Our ref: DOC20/814200

Your ref: SSD-8184

Subject: EES comments on the Environmental Impact Statement for Fairfield Sustainable Resource Centre expansion (SSD-8184) – corner of Hassall Street and Widemere Road, Wetherill Park

Attachment A**Subject: EES comments on the Environmental Impact Statement for Fairfield Sustainable Resource Centre expansion (SSD-8184) – corner of Hassall Street and Widemere Road, Wetherill Park**

FIGURE 08  
EXISTING 1% AEP HAZARD

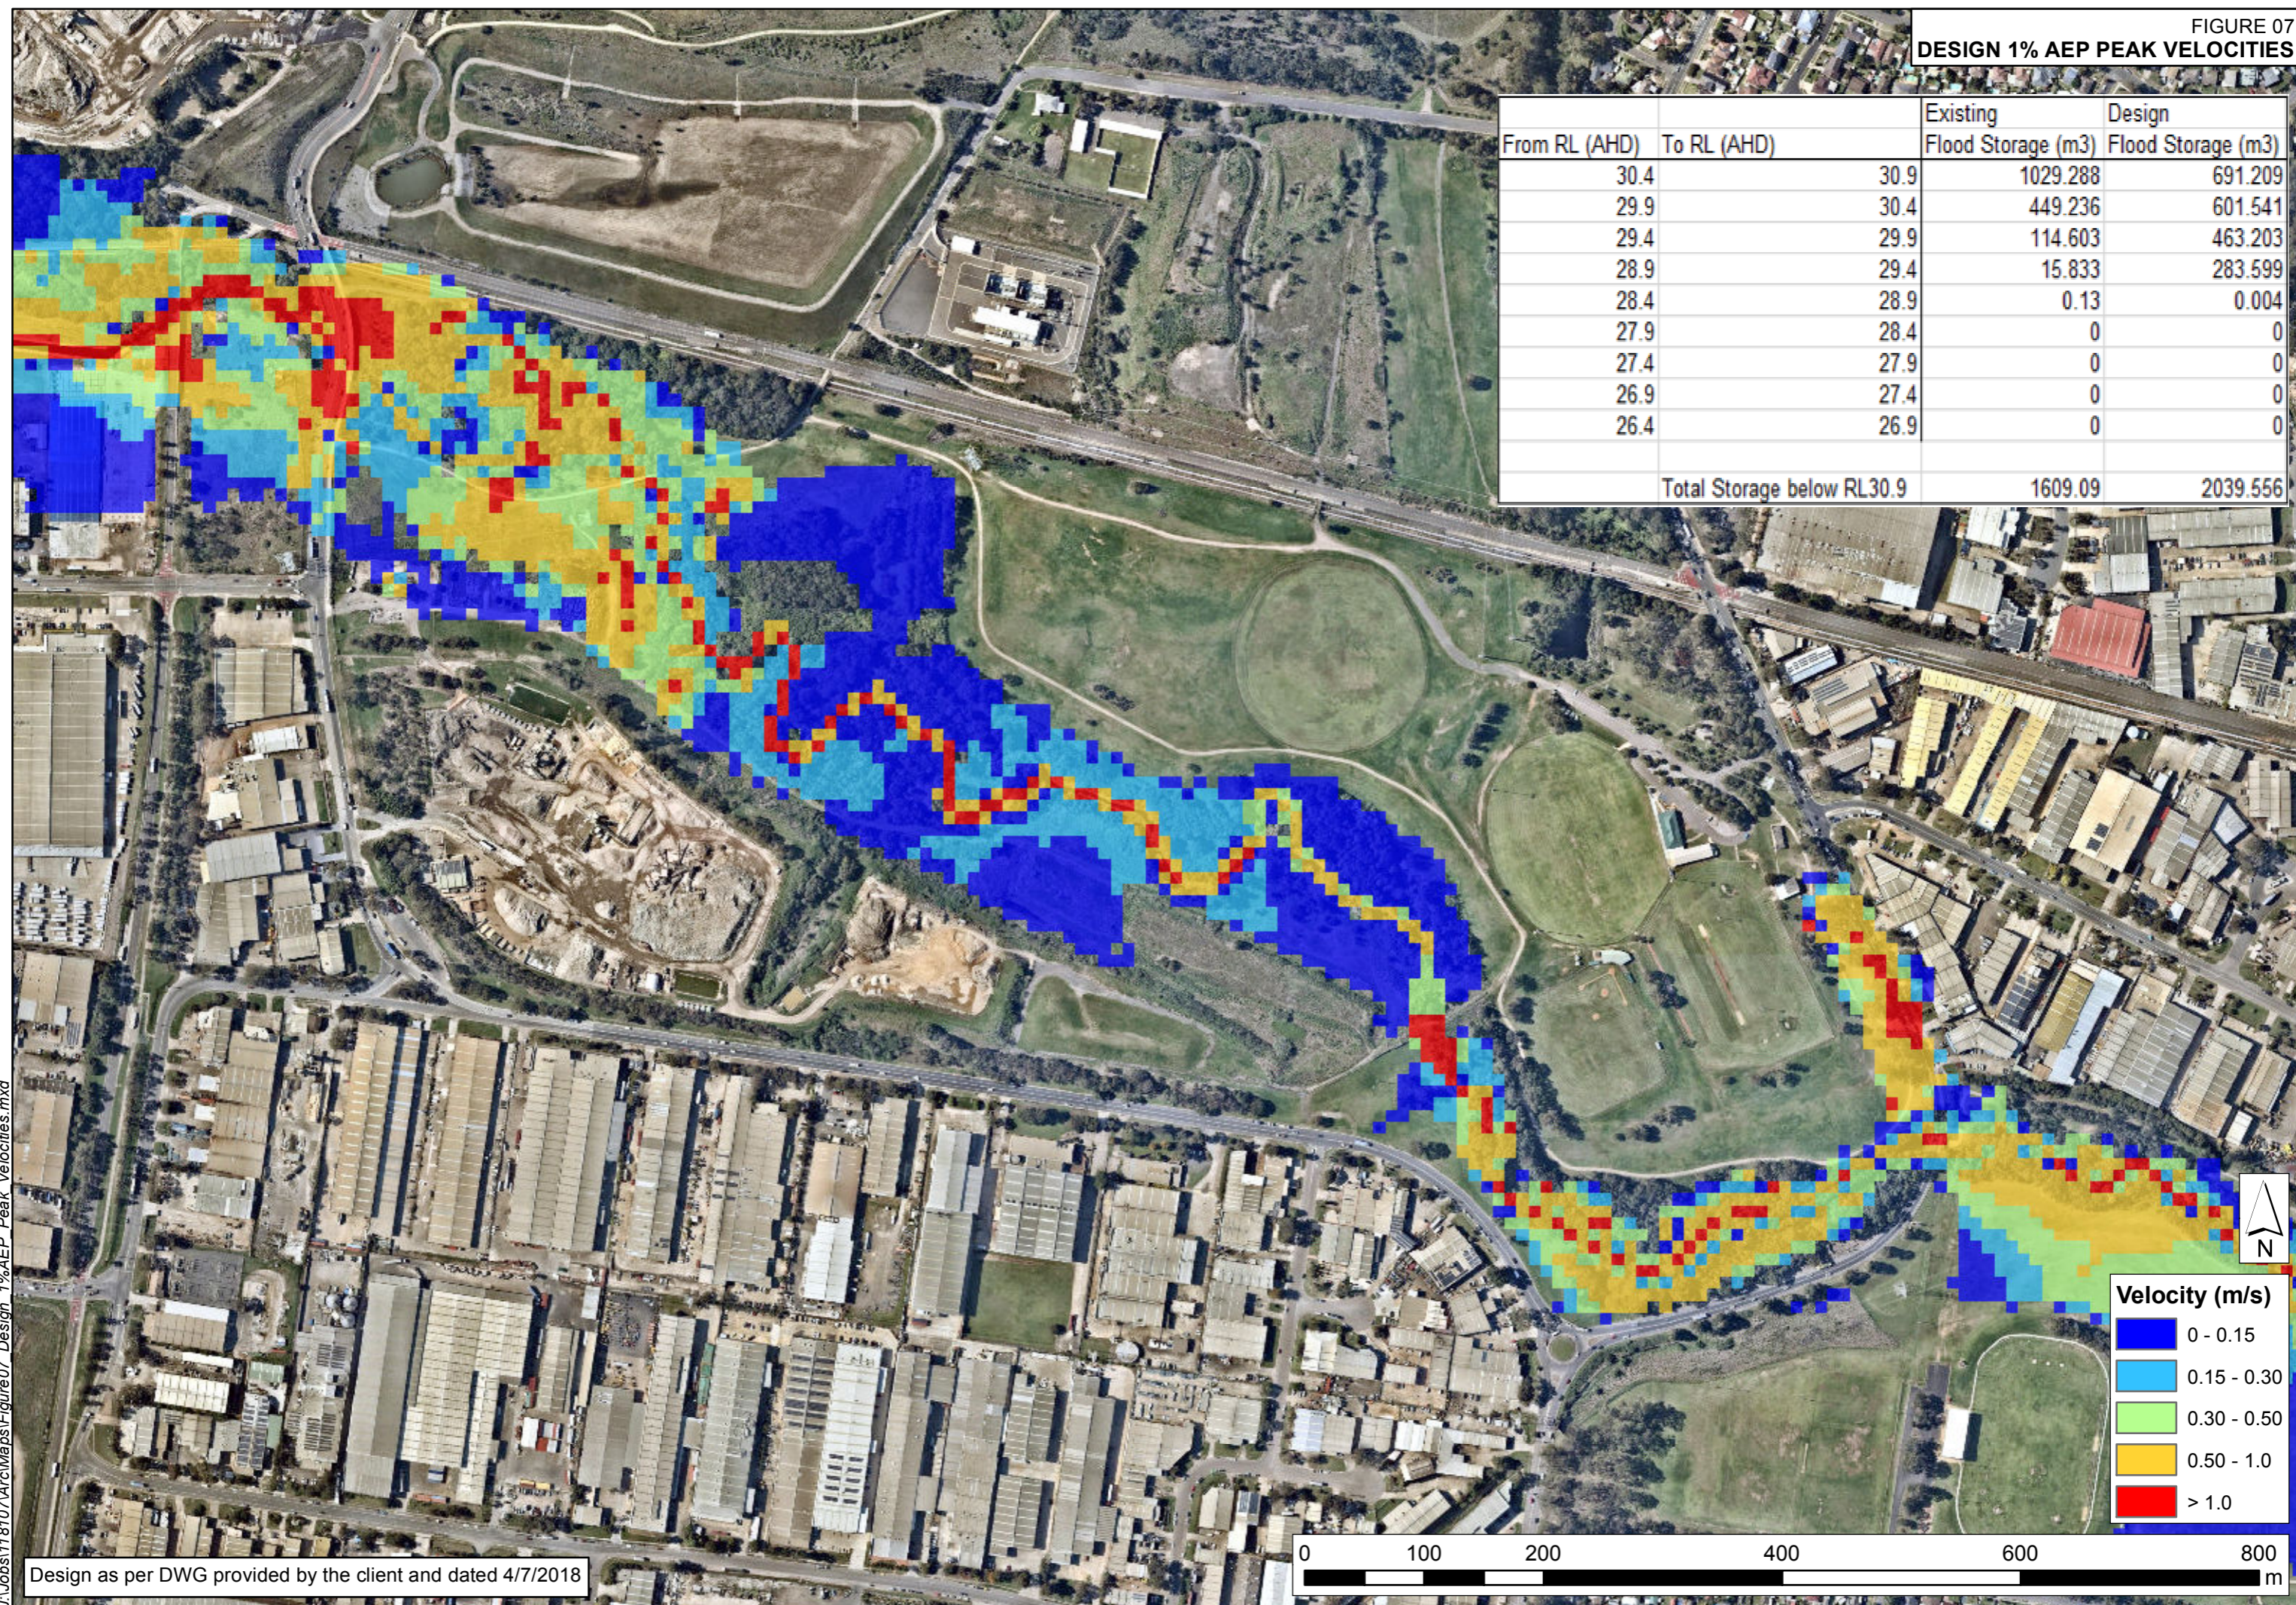
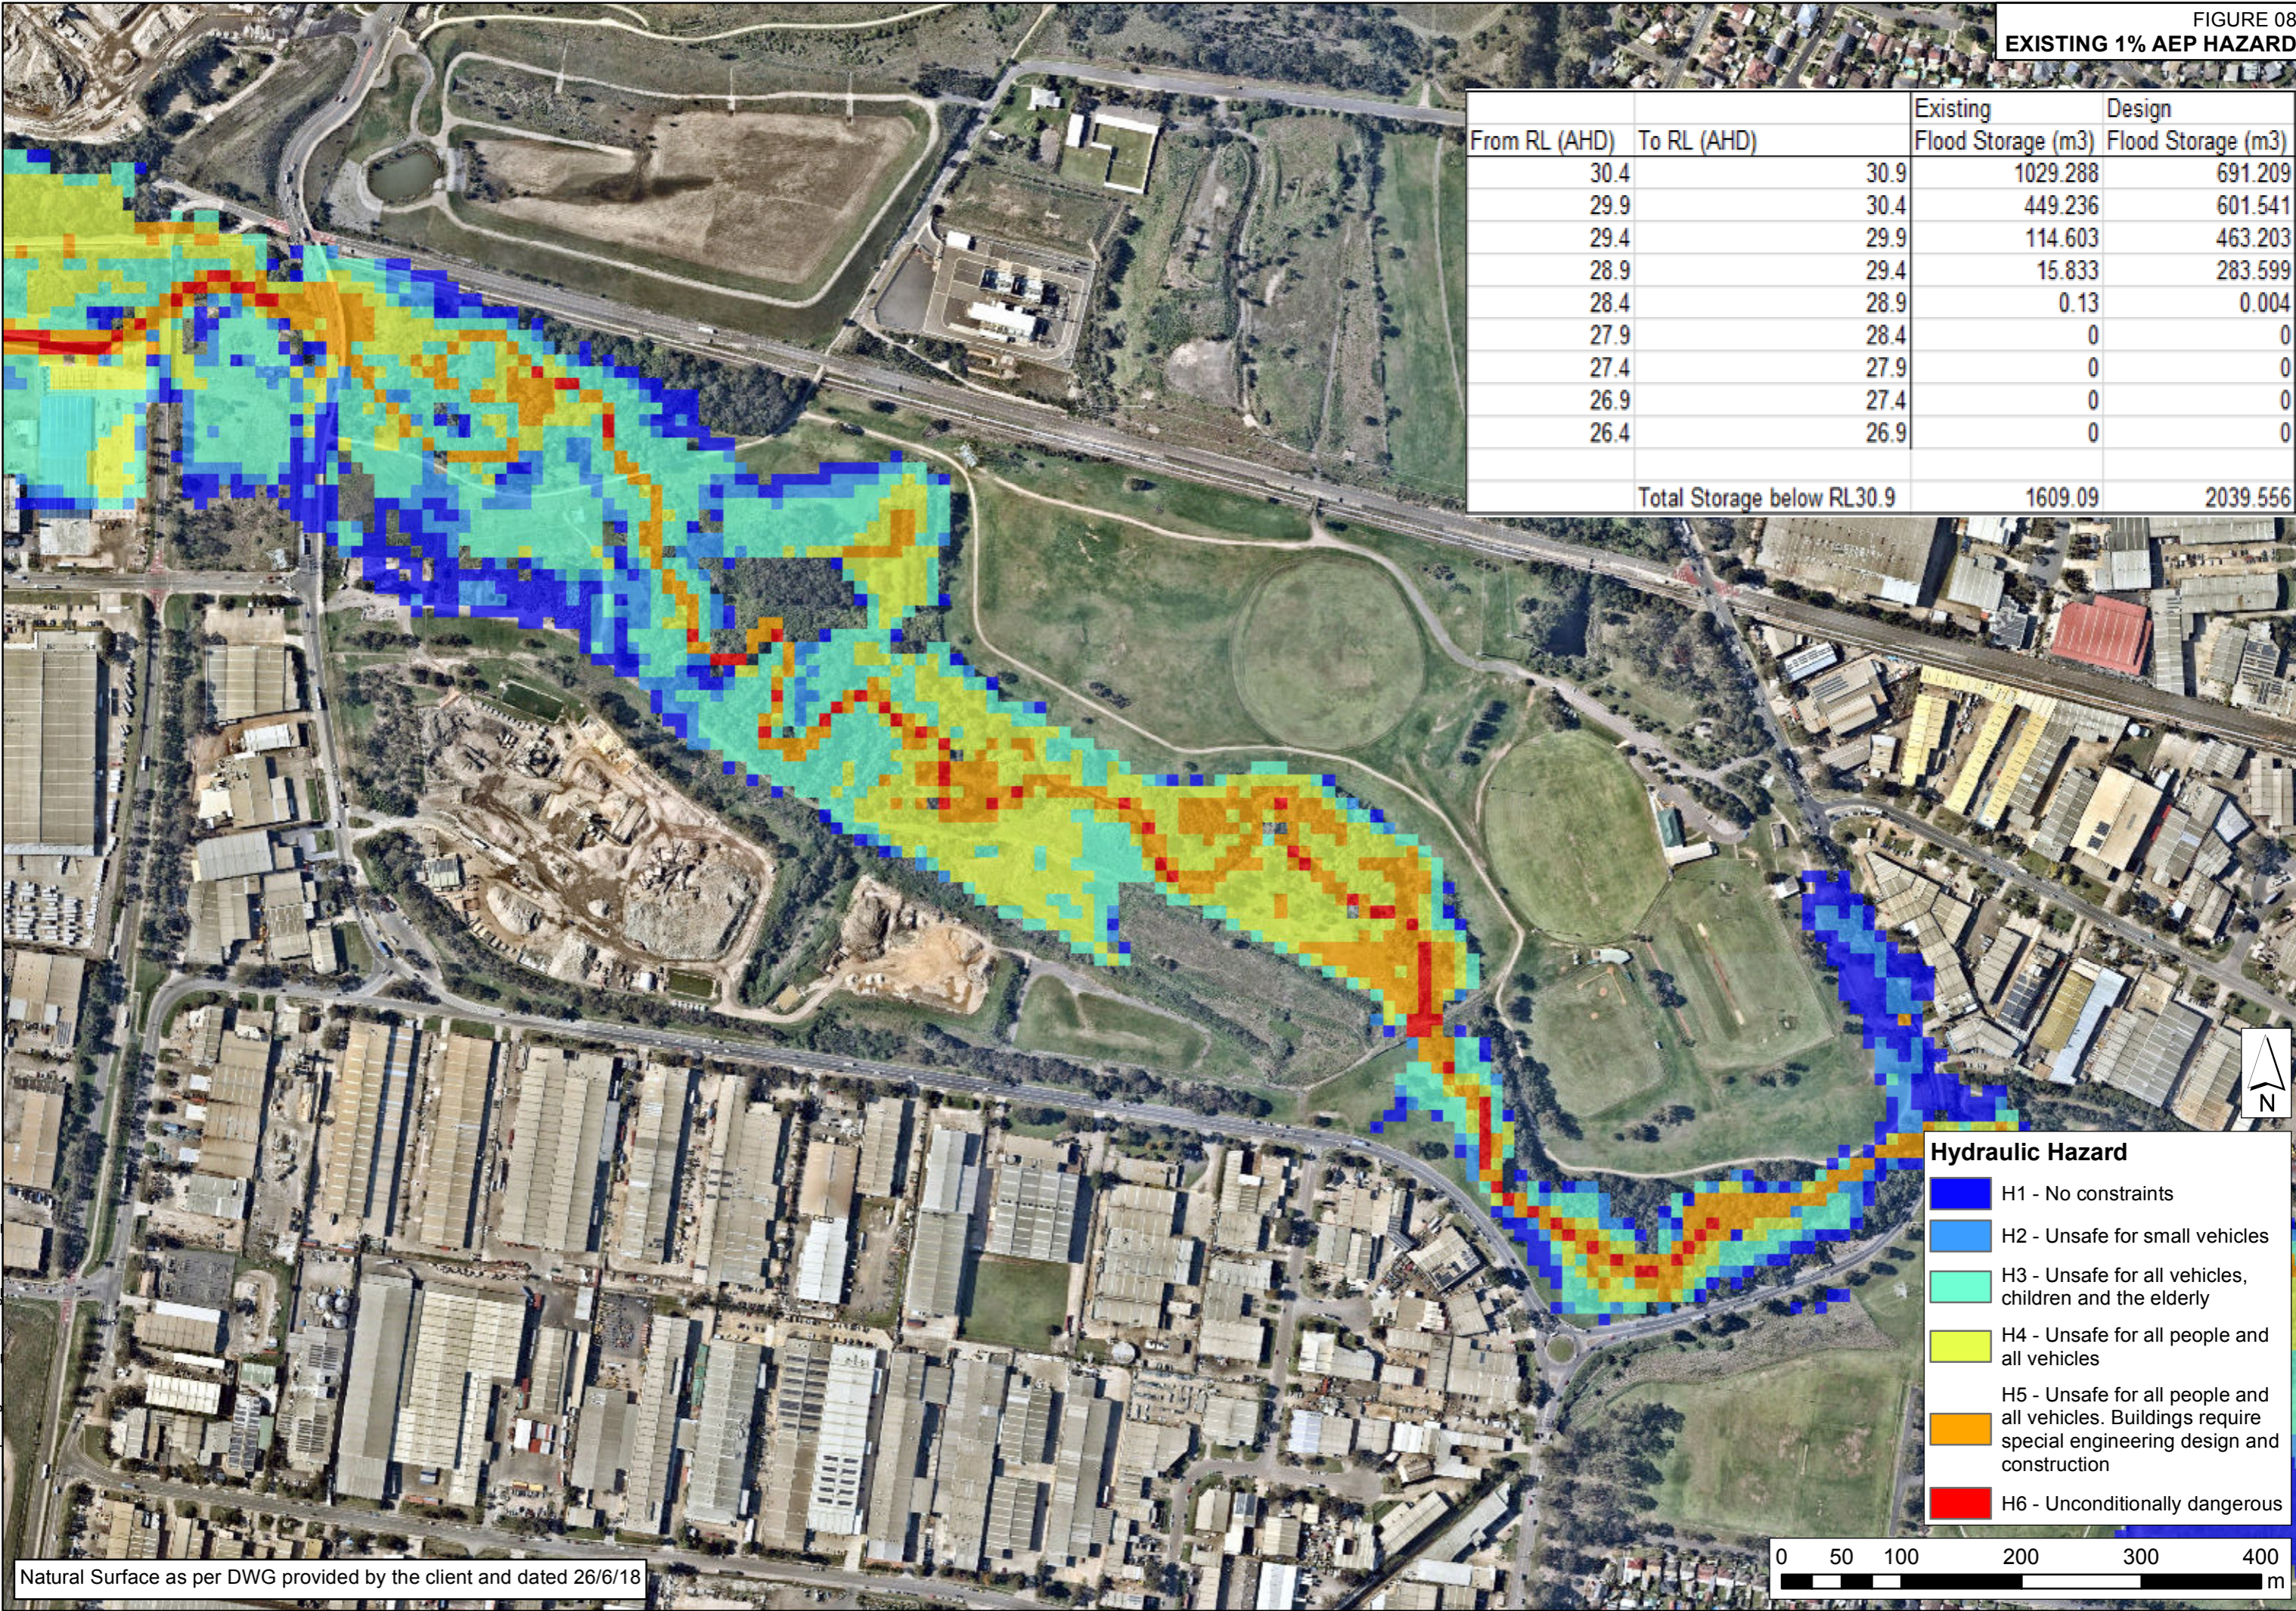
2. The flood assessment should consider the impact from the full range of floods (up to the Probable Maximum Flood) for both mainstream and overland flooding. The latter is addressed in Fairfield Council's Wetherill Park Overland Flood Study. Road inundation problems become important during times of flood and need to be appreciated by the owners and occupiers at the sustainable resource centre (SRC) site.

3. Climate change implications are expected to be minor at this site but nevertheless should be considered in the flood assessment. Sea level rise will impact the downstream end of Prospect Creek at the Hume Highway/Lansvale area. It is possible that the combination of sea level rise and increased rainfall could impact flood levels along the length of Prospect Creek. In 2011, Fairfield Council prepared a report entitled "Georges River and Prospect Creek Climate Change Sensitivity Assessment". For overland flooding, the assessment should consider a 10%, 20% and 30% rainfall increase. For mainstream flooding the 0.5% and 0.2% AEP events can be adopted as a proxy. The proposed development particularly the flood mitigation facilities should be designed to accommodate the potential climate change impacts. The 0.5m freeboard should not be eroded to account for climate change impacts.

5. The EIS should incorporate appropriate management measures regarding a Flood Emergency Plan, a binding requirement ensuring the proposed 1500m³ flood storage area is used exclusively for flood storage and the limiting of activities or works within the lower parts of the Prospect Creek floodplain, identified as a High Flood Risk Precinct, and in accordance with Fairfield Council's Development Control Plan for flooding.
